## The Lake Lothing (Lowestoft) Third Crossing Order 2020

### List of corrections to the Order requested by Suffolk County Council

11 June 2020

INSET B
Improved and new highway carriageway along
Riverside Road at ground level below the new bridge.
(SCALE 1:1000)

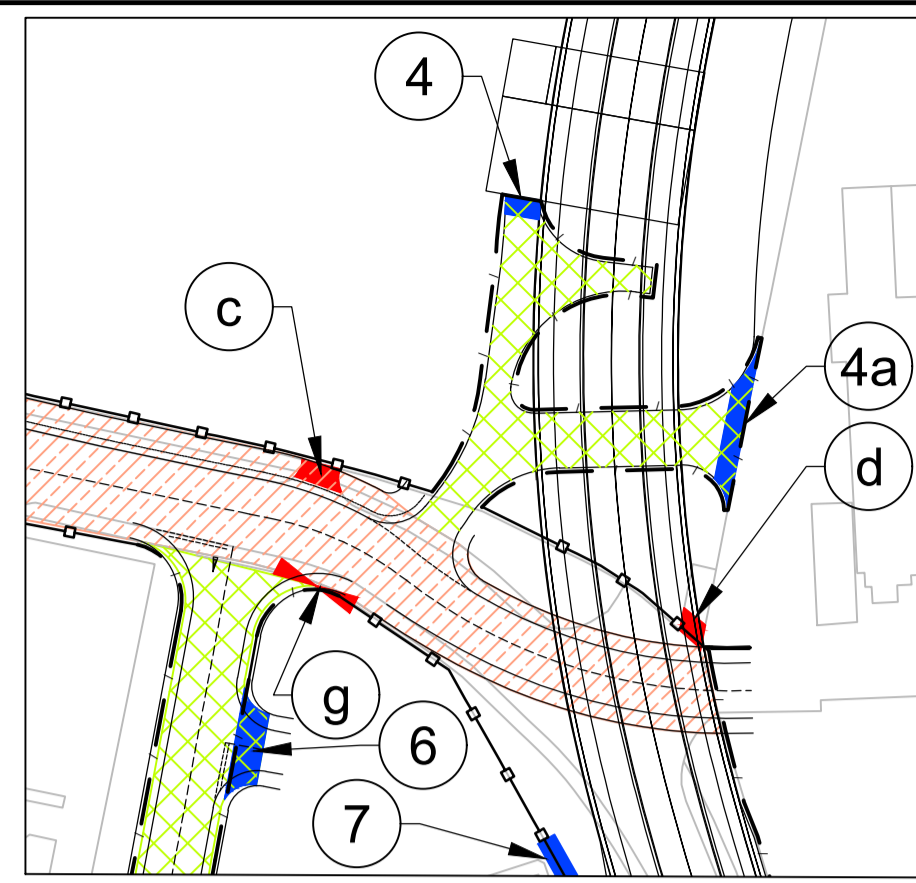
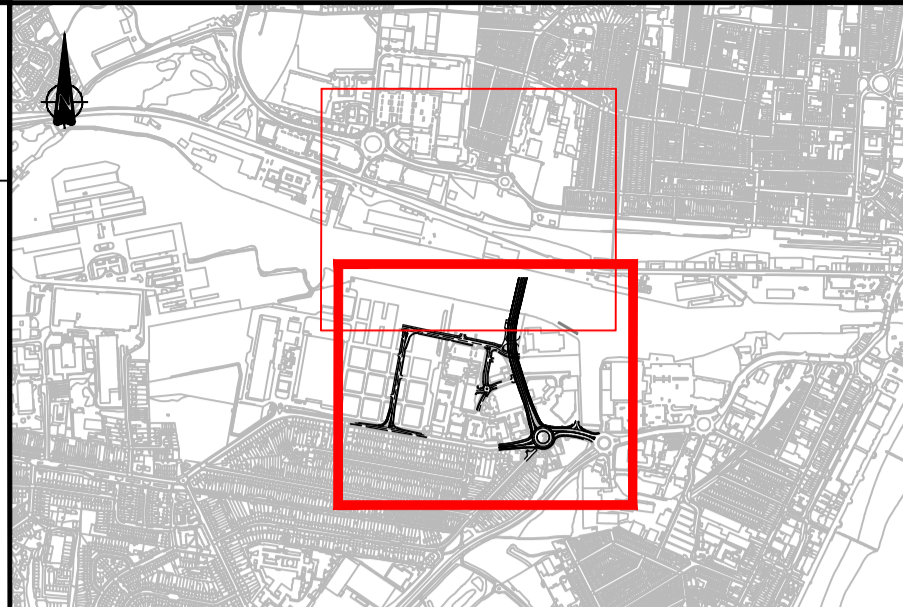
We also enclose a revised version of Sheet 2 of the Rights of Way and Access Plans, which we should be grateful if you would also accept in substitution for the version submitted at Deadline 10 (REP10-023). The Deadline 10 version (REP10-023) includes green hatching representing new highway forming the northernmost part of the new turning head at Canning Road (NMC1), as accepted in the Examining Authority's Procedural Decision (PD-015); however, the hatched area has not been allocated a reference number and corresponding entry in the related Schedule to the DCO. This unintentional oversight has been corrected in the enclosed revised version of Sheet 2 of the Rights of Way and Access Plans, where the green hatched area of new highway comprising part of the new turning head is labelled 'Reference F'. A corresponding entry (identifying new highway Reference F) has been added to Part 1 of Schedule 4 in the enclosed mark-up of the draft DCO.
